From: [Jon N](#)
To: [East Pye Solar](#)
Cc: [REDACTED]
Subject: Subject: Formal Objection to East Pye Solar Project (Reference: EN0110014) – Visual Encroachment and Heritage Settings Harm at Hawes Green (Site 8)
Date: 20 September 2026 20:10:30

I am writing to register my formal objection to the proposed **East Pye Solar Project**, specifically concerning the unacceptable, unmitigated visual impact of **Site 8** (sub-sites 8A and 8B) on **Hawes Green** within the **Shotesham Conservation Area**.

Figure 26. Site 8 showing Grade I and II* Listed Buildings

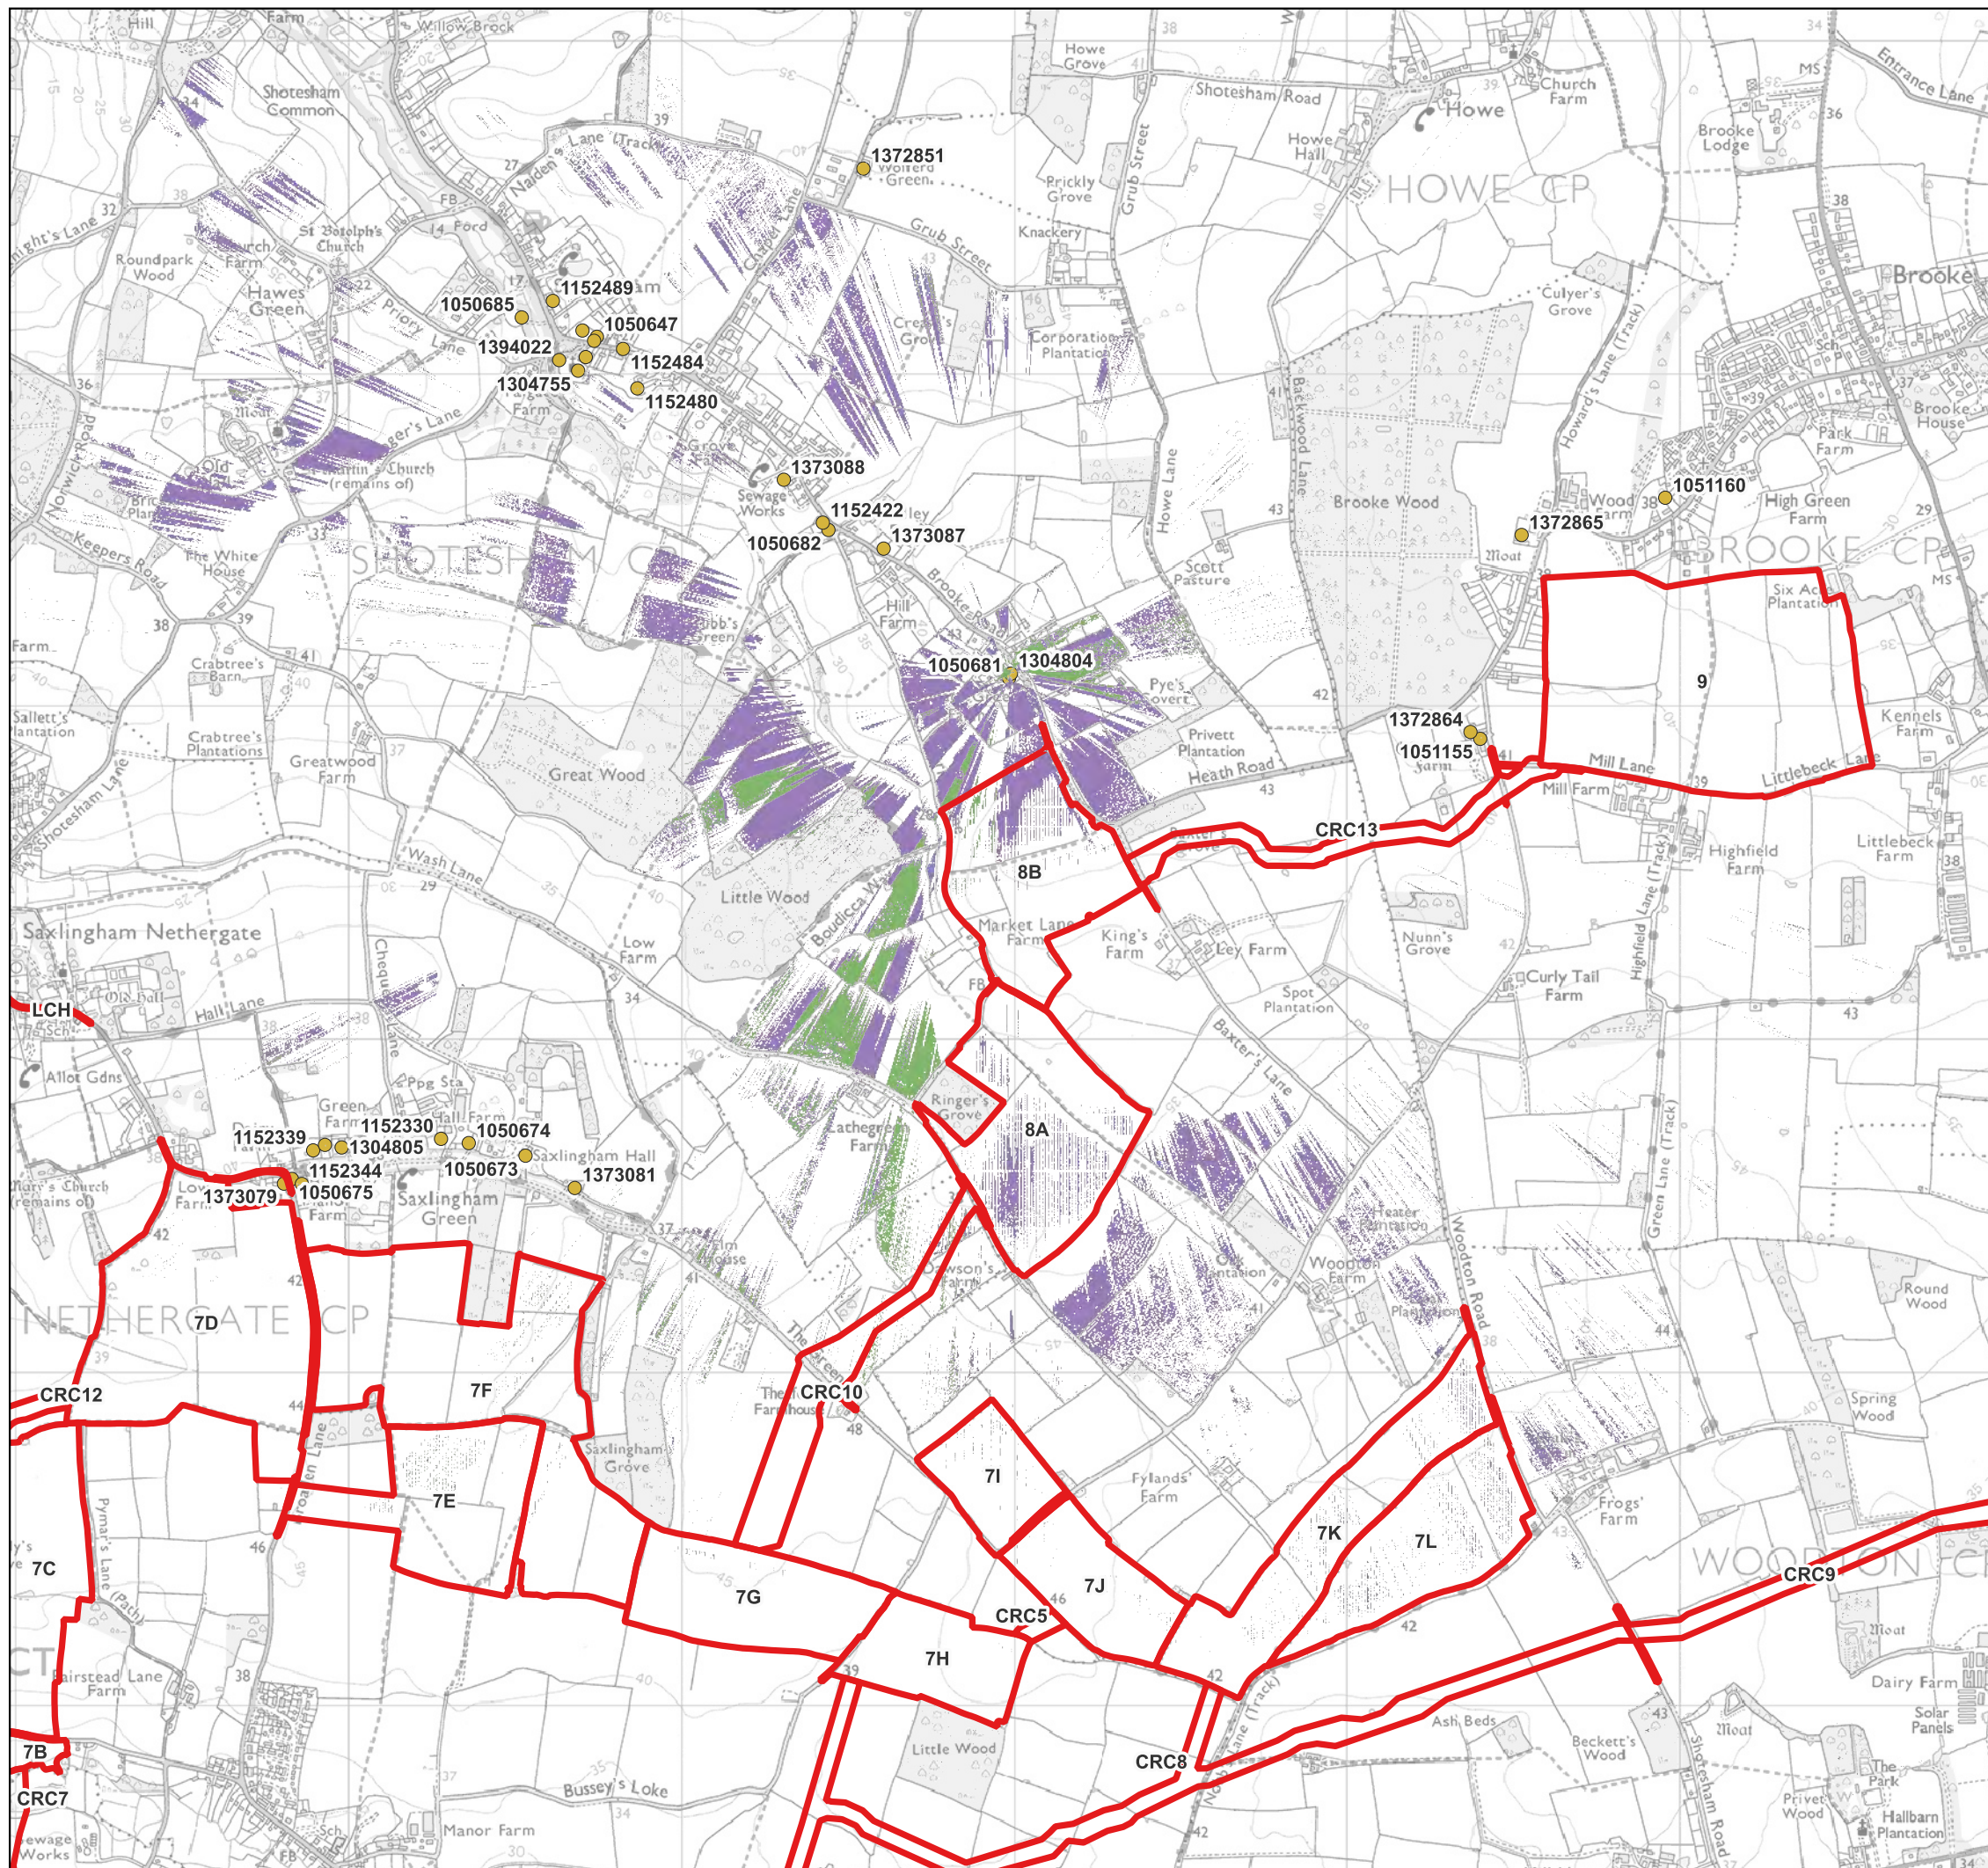
I am a permanent resident of Hawes Green, living within a highly sensitive and protected historic landscape. Our properties sit in immediate visual and historic alignment with an exceptional national heritage cluster, including the Grade II* listed **St Mary's Church** and the Grade II listed ruins of **St Martin's Church**.

Under Section 66 of the Planning Act 1990 and Historic England's GPA3 policy framework, the rural backdrop and immediate approach to our homes and medieval churches are strictly protected. The developer explicitly admits that **"glimpses" and "glimmers"** of the industrial solar arrays will pierce the tree lines right outside St Mary's Church path. An admission of a glimpse is a legal admission of an unmitigated line of sight. Introducing a massive, metallic, industrial infrastructure layer into this historic viewshed shatters the rural tranquility and group value of this designated Conservation Area.

Figure 28. Visibility Analysis Site 8

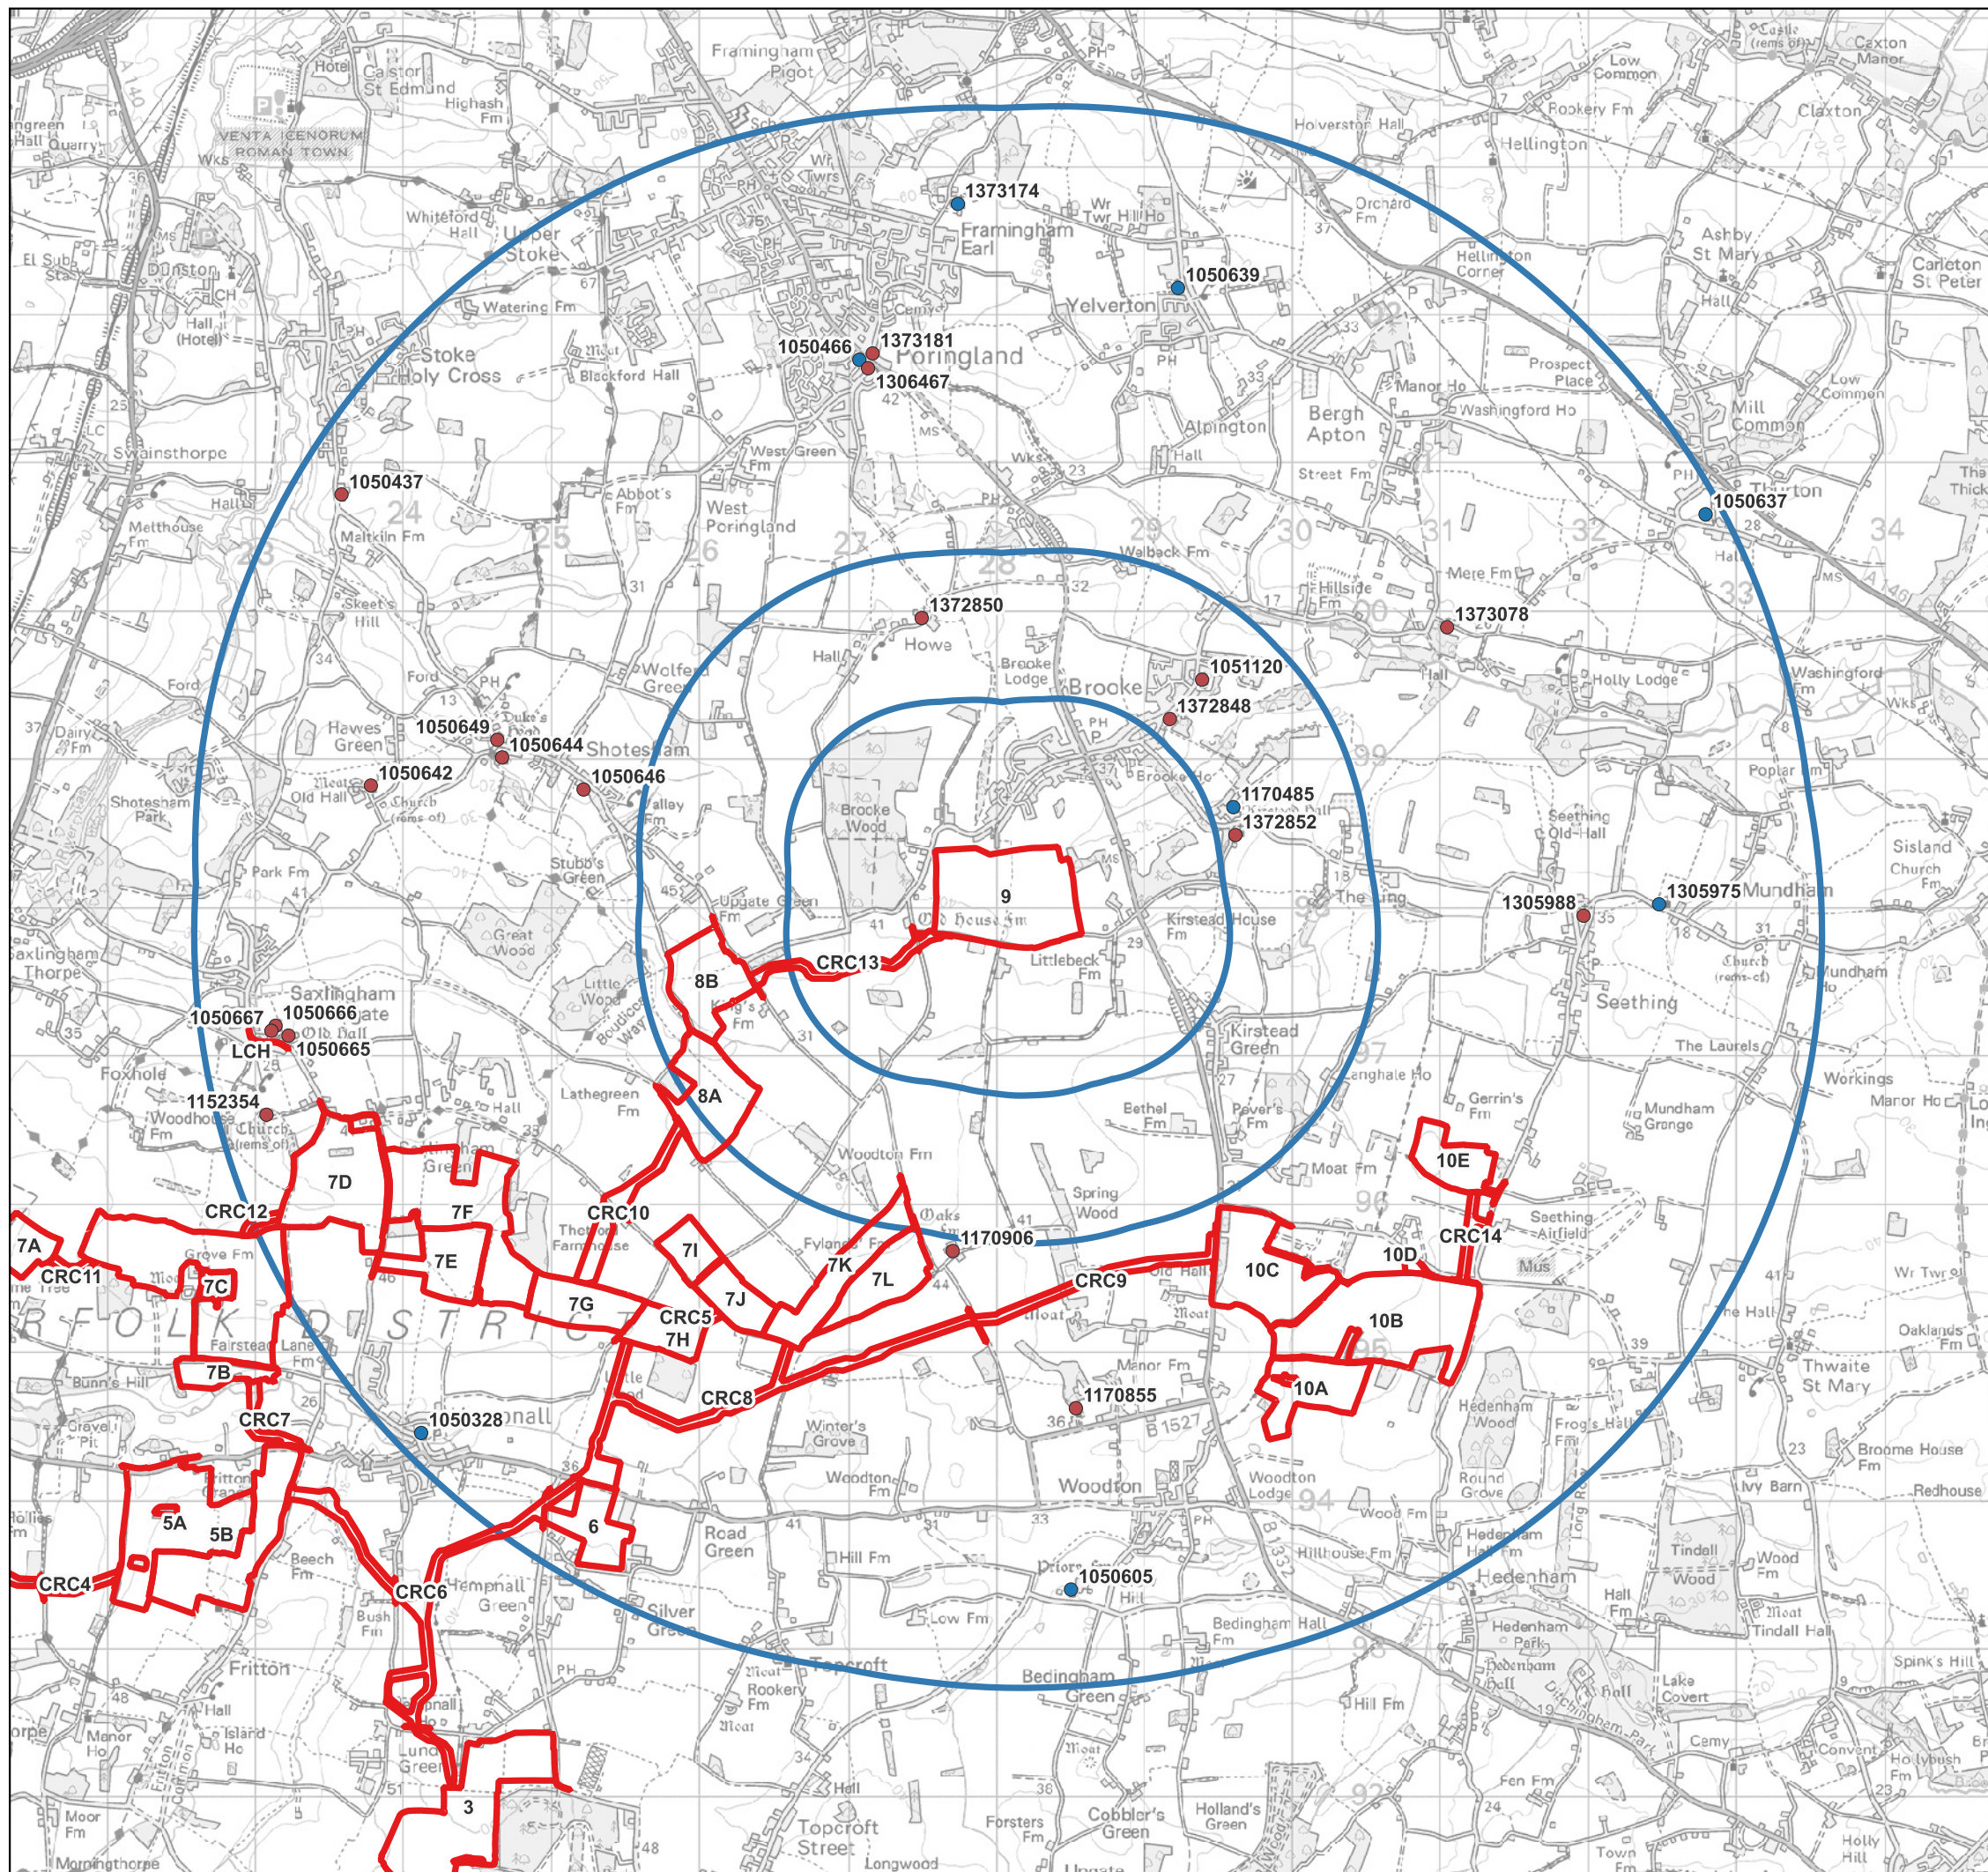
The developer claims that ground-level hedges along the valley floor and existing woodland blocks will screen the panels. This is a topographical fallacy. Because the terrain rises toward Hawes Green, ground-level hedges at the bottom of the valley cannot hide 4.5-metre-high panels viewed from an elevated ridge.

Furthermore, the woodland between our ridge and Site 8 is heavily deciduous; it completely loses its leaves for half the year, leaving the stark, industrial grid completely on view all winter.

I formally request that the Examining Authority mandate the developer to produce a **verified line-of-sight topographical cross-section** from the St Mary's Church path directly to Site 8, and that an **Accompanied Site Inspection (ASI)** be conducted from our ridge. I urge the Inspectorate to recommend the total removal of Site 8 from the final masterplan.
